June 12, 2015

Subject: Geotechnical Third Party Review
5637 E. Mercer Way
Mercer Island, Washington
Perrone Consulting Project #15124

PROPOSED RESIDENCE SECTION

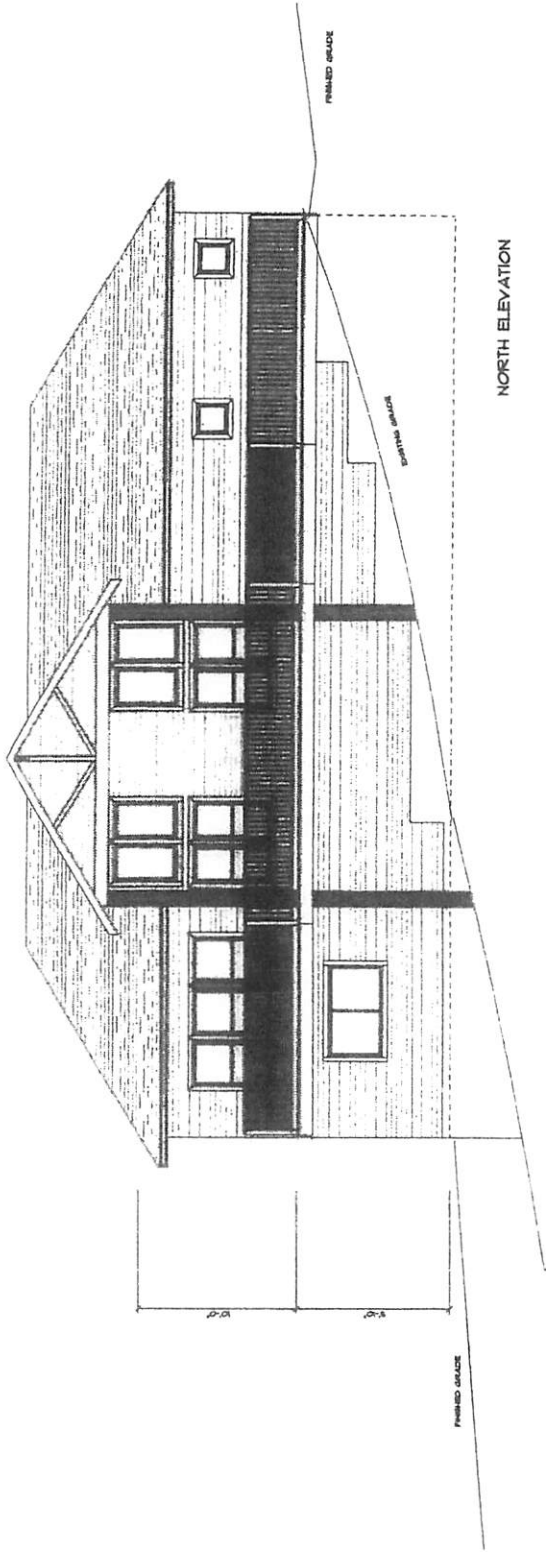
We recommend that the geotechnical engineer provide additional information and slope stability analyses to address the following issues: (a) whether temporary shoring will be required for the basement excavations to preclude instability of the hillside and adjoining properties; (b) whether additional mitigation measures such as ground improvement will be required to provide adequate long term slope stability factors of safety for static and seismic conditions; (c) if additional protections such as a debris catchment wall will be required to protect the proposed structure.

We concur with Geo Group NW assessment that liquefaction is likely to occur during the design earthquake event so that the proposed pile foundations are appropriate. Additional information should be provided to address liquefaction impacts to pile foundation design including lateral load resistance and downdrag, and liquefaction effects on lateral earth pressures on basement walls.
